Change of use of land to storage (B8 Storage or Distribution), erection of barn & hardstanding (resubmission following A/111/17/PL).

Land at Arundel Road/A27 Angmering

Thank you for your internet representation made on 19th February 2018 which has been recorded as '**an objection**' with the comments as follows:

Title:
Site Access with Southern Visibility Splay

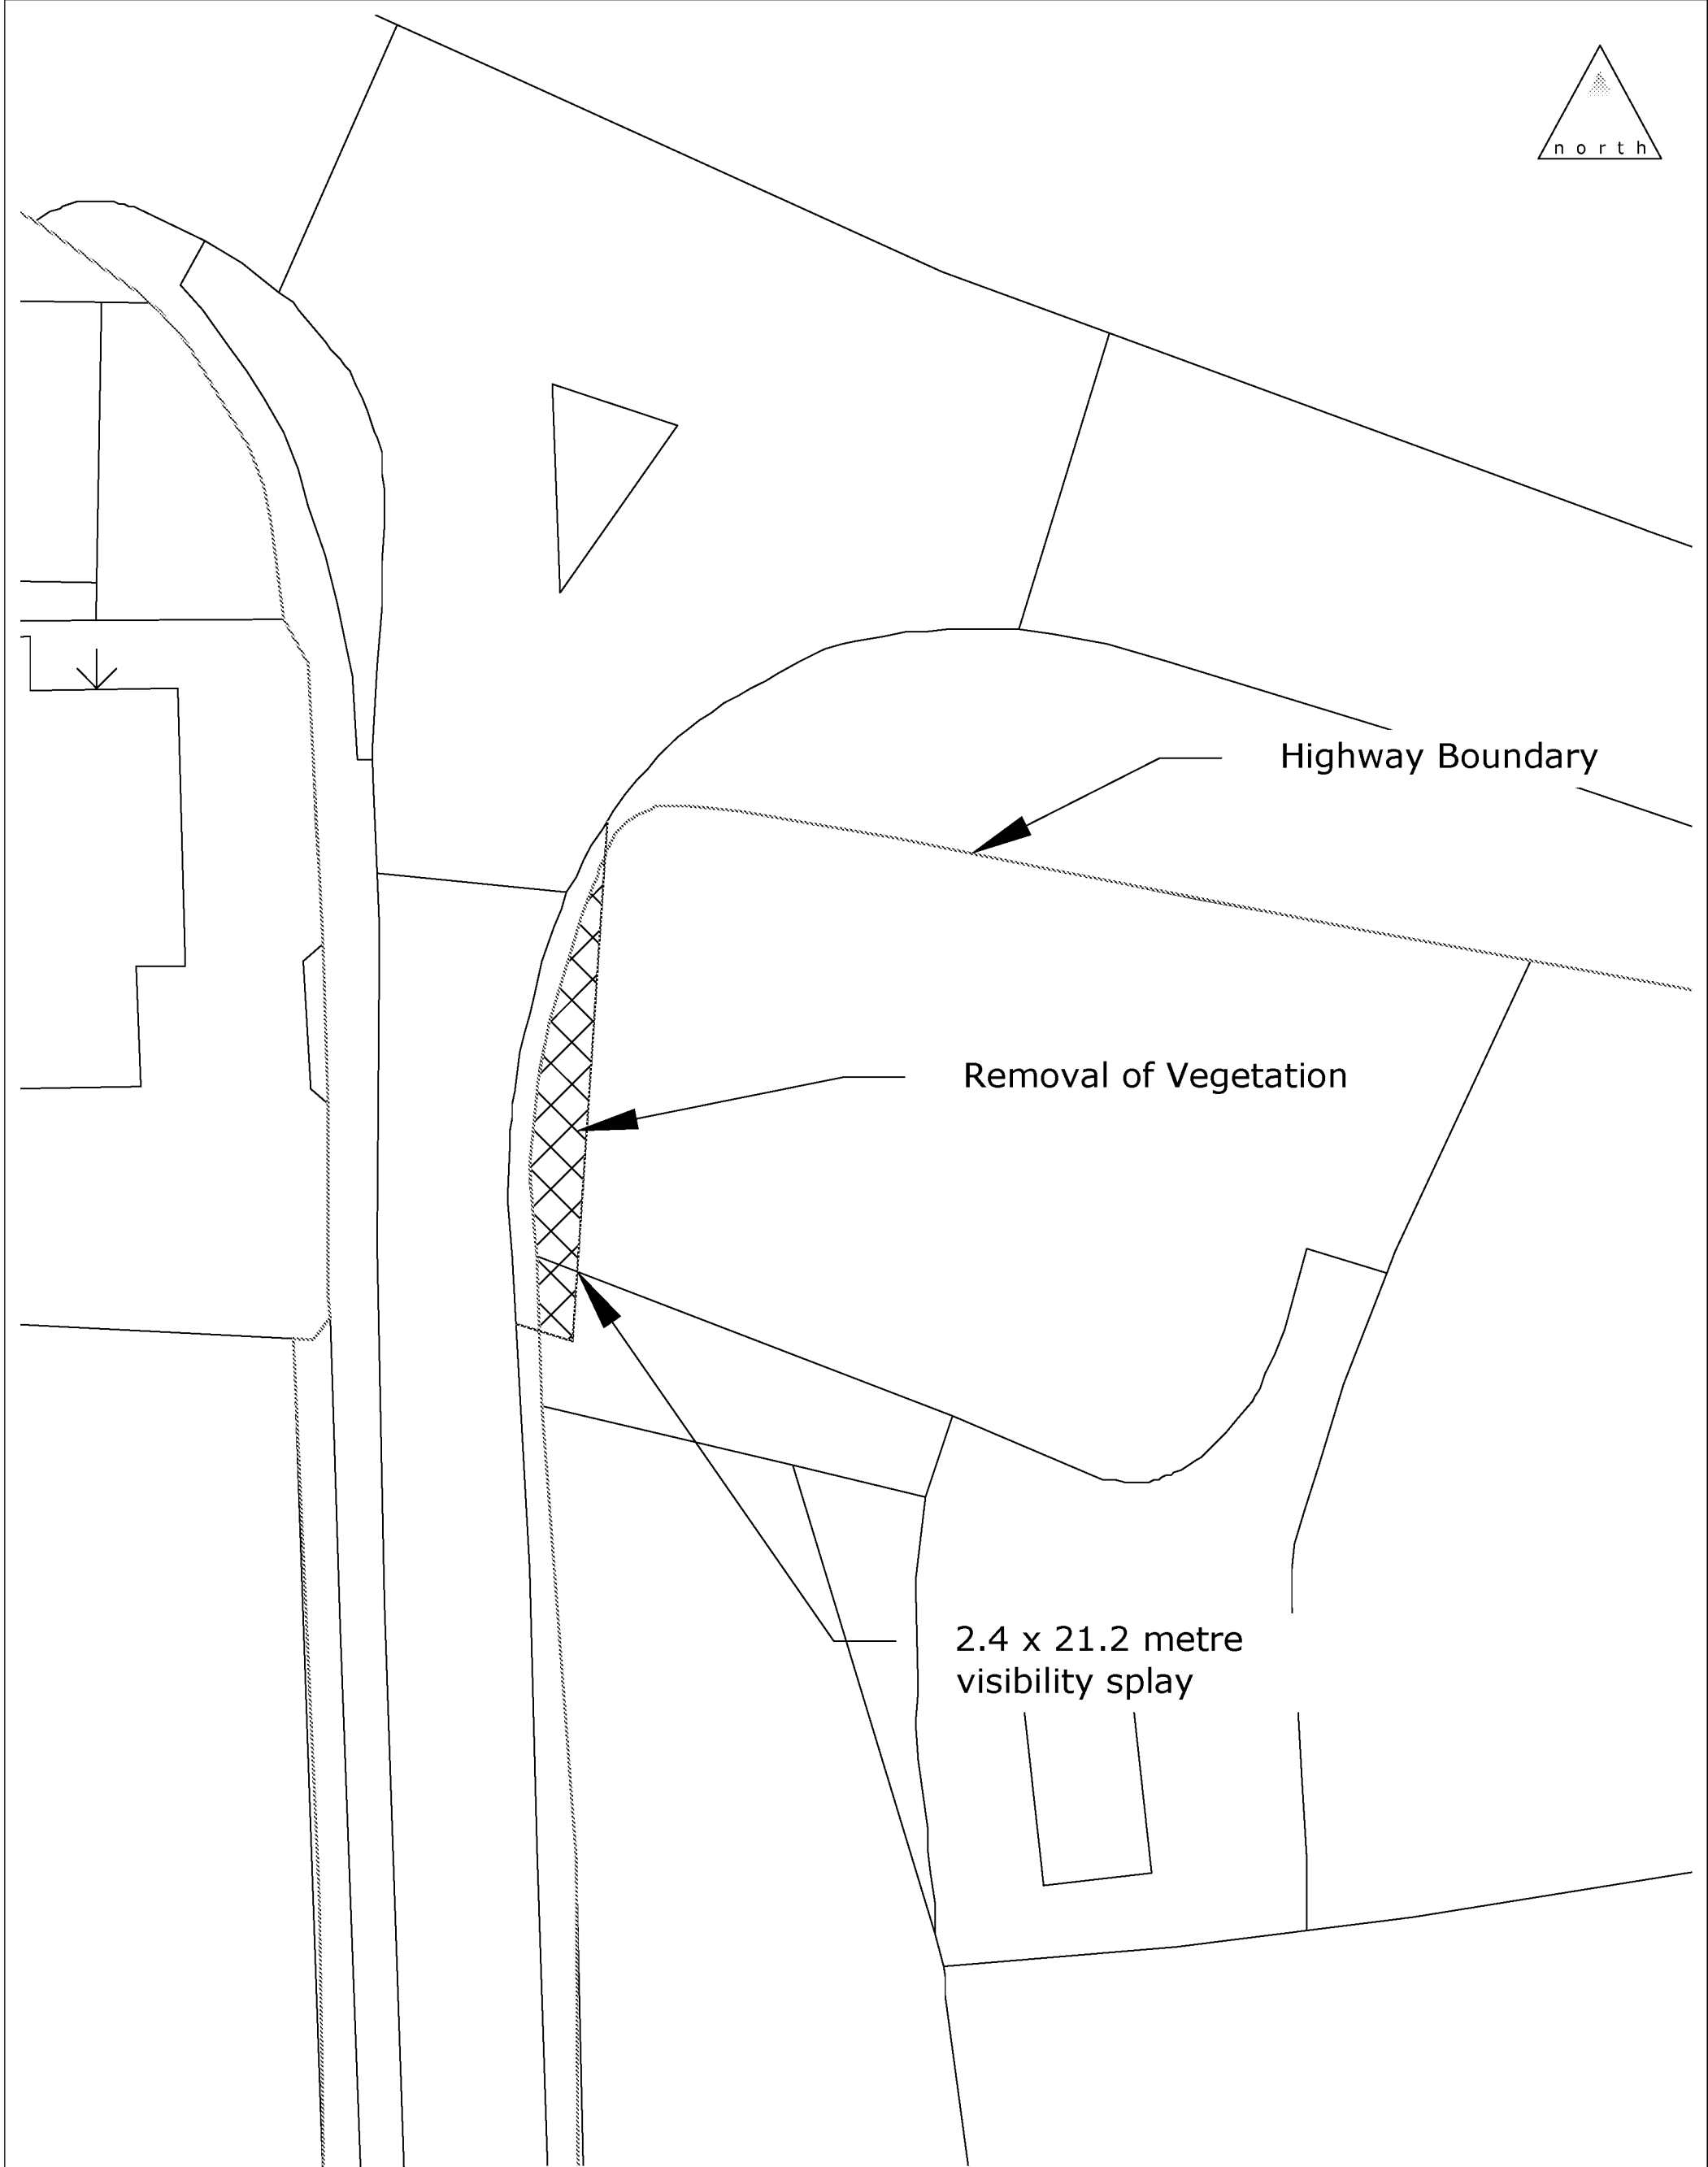
I have to object to the proposed use of this parcel of land on the grounds of access and visibility. The surrounding hedges north of the site entrance, have recently been cut back and this does improve visibility slightly for and of vehicles approaching from the A27. However, no such work can realistically be carried out to improve the negligible view from the site of traffic approaching from the south, within Arundel Road.

Drawing:
1711056-TK01

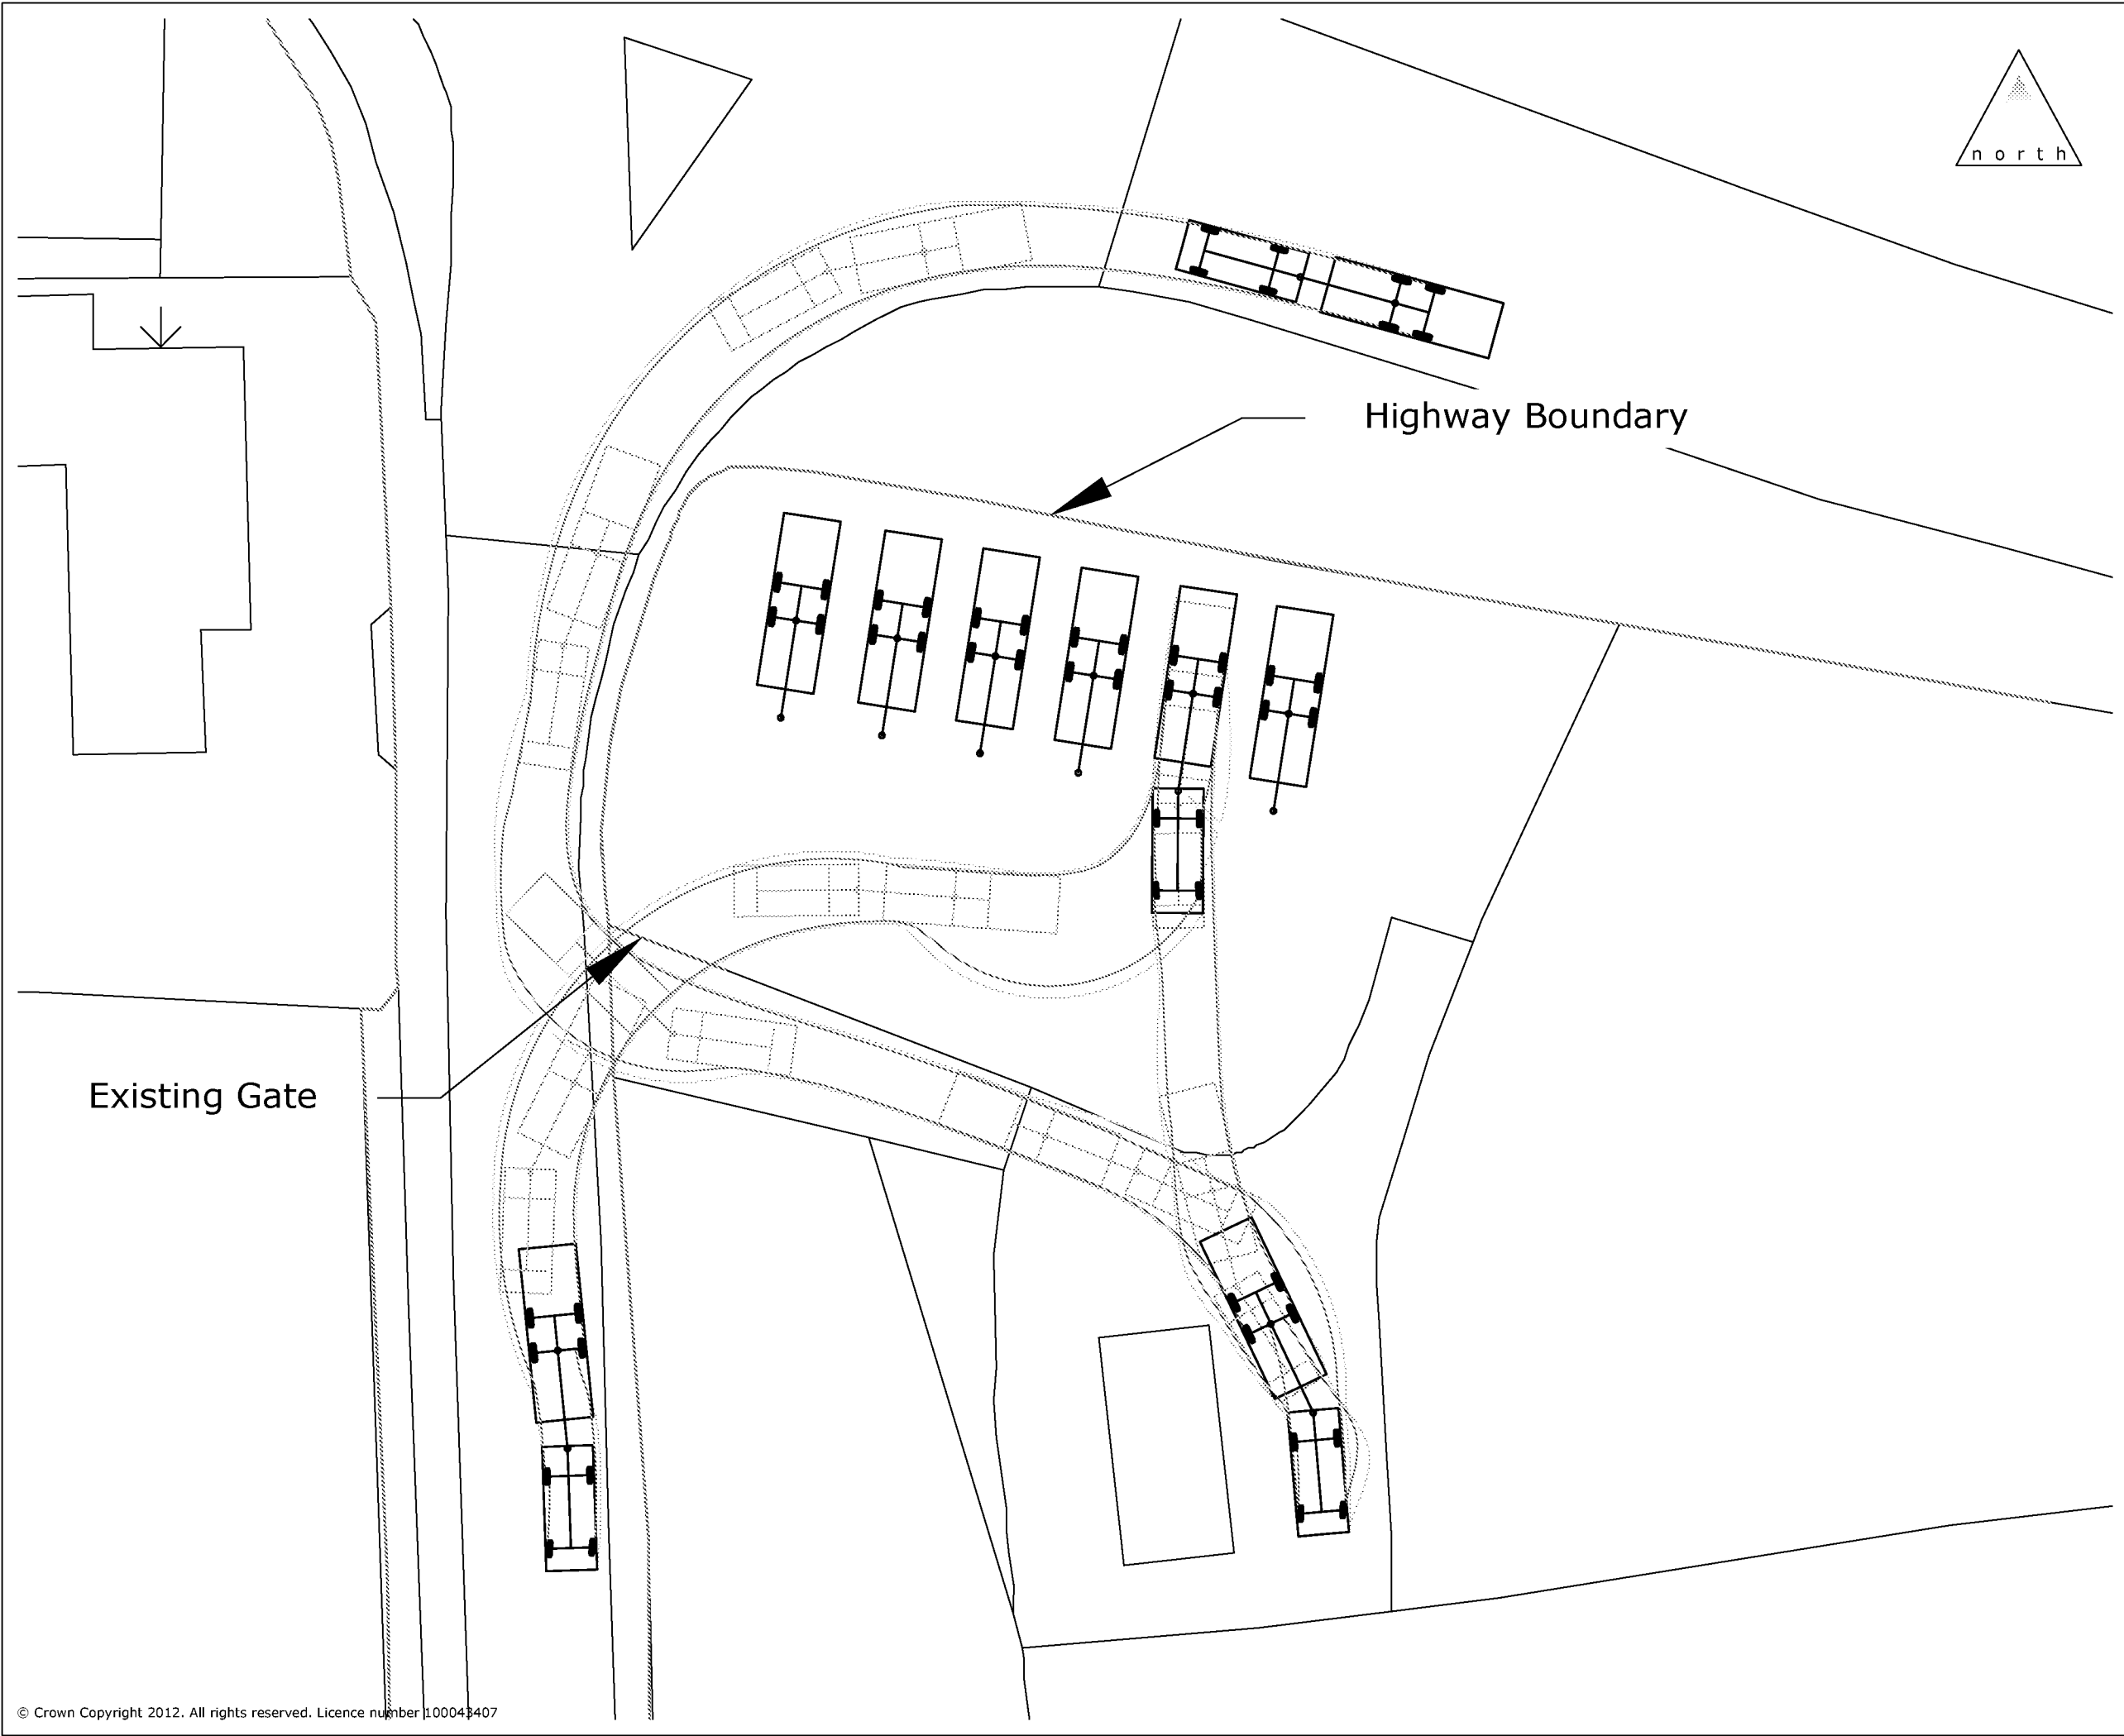
The biggest difficulty however, lies with the proposer's need to access the land with large trailers, which, owing to the restrictions presented by the plot's topography, must be reversed into the site. This requires the use of boards to be laid across the south bound lane from site's access "bell mouth" in order to mitigate the difference in levels between the carriageway and the site - to prevent the trailers grounding out. The proposer is correct that they use a banksman but the banksman is occupied with the task of directing the driver onto the land whilst overseeing the passage of the trailer along the levelling boards. He cannot control traffic on two sides of a vehicle. In practice, this operation can easily take 5 to 10 minutes, during the bulk of this time, the carriageway is completely blocked (I have observed this operation in part, a number of times so far, when entering Arundel Road from the A27 and have been most concerned with the possibility of following vehicles rounding the corner and colliding with the rear of my own vehicle).

The campsite (located some 165 metres south of Arundel Acre and on the same side of the road) was obliged to install a suitable metalled surface of sufficient size to permit the length of vehicles accessing that site, to pull up to the gate and stop clear of the carriageway; it would seem logical that similar requirements be made of this land if access by long vehicles is to be permitted. I note the previously supplied swept path analysis. It seems somewhat disingenuous to consider a car / caravan combination when in reality the drawing vehicle will be by necessity a commercial vehicle and the trailers have up to 3 axles. Additionally, the manoeuvre depicted presumes a level surface and not an acute change of angle at the road / site interface.
